From: Amanda Scholes on behalf of Planning.Responses
Sent: 07 November 2017 08:49
To: Planning Scanning
Subject: FW: WA/73/17/OUT - Land East of Wandleys Lane and West of West Walberton Lane, Fontwell.

Application No: WA/73/17/OUT

Site: Land East of Wandleys Lane and West of West Walberton Lane, Fontwell.

Proposal: Outline Planning Application with some matters reserved for up to 157 No. residential dwellings including 30% affordable. This application is a Departure from the Development Plan.

Drawing Issue Status					
INDICATIVE - FOR INFORMATION					
LAND EAST OF WANDLEYS LANE A27 / A29 WEST ROUNDABOUT JUNCTION GEOMETRY					
Client					
WELBECK STRATEGIC LAND II LLP					
Date of 1st Issue 29.09.17		Designed JHJ	Drawn MJB		
A3 Scale 1:500		Checked GH	Approved GH

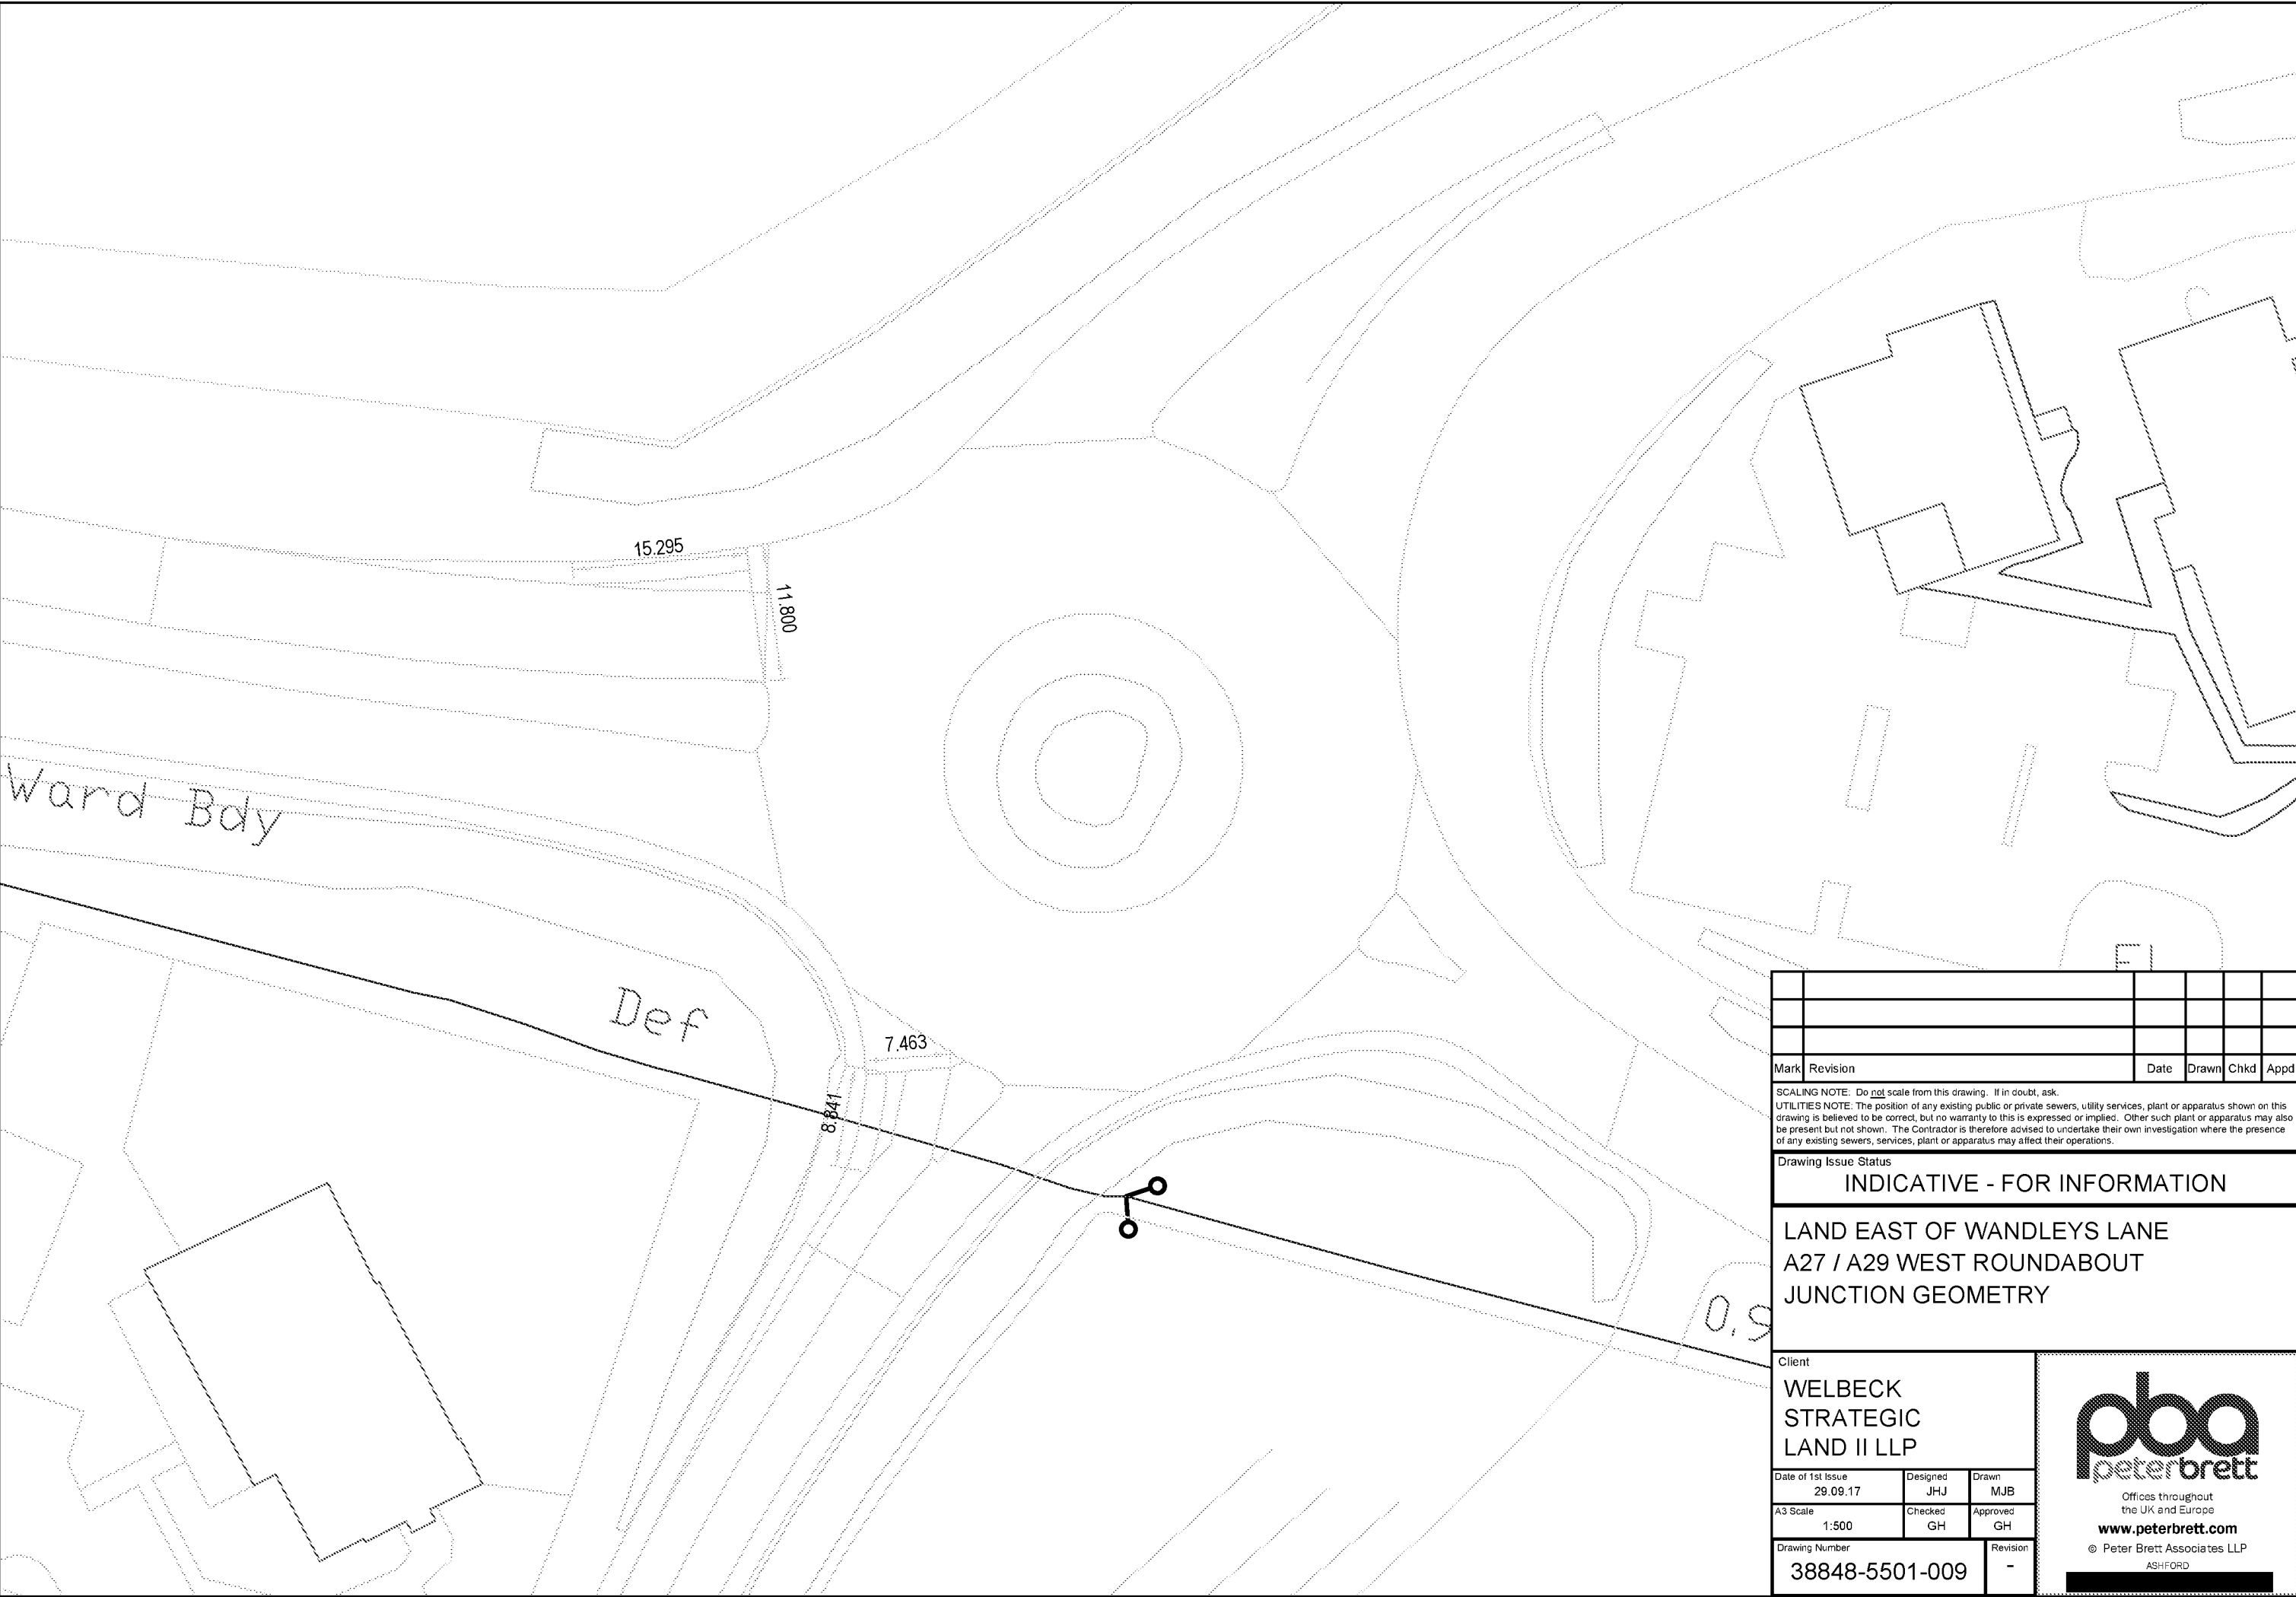
- Paragraph 8.6.3 states that the proposed A27 / A29 West roundabout mitigation is contained in Appendix M, but there does not appear to be such a plan and thus clarification is sought on this.
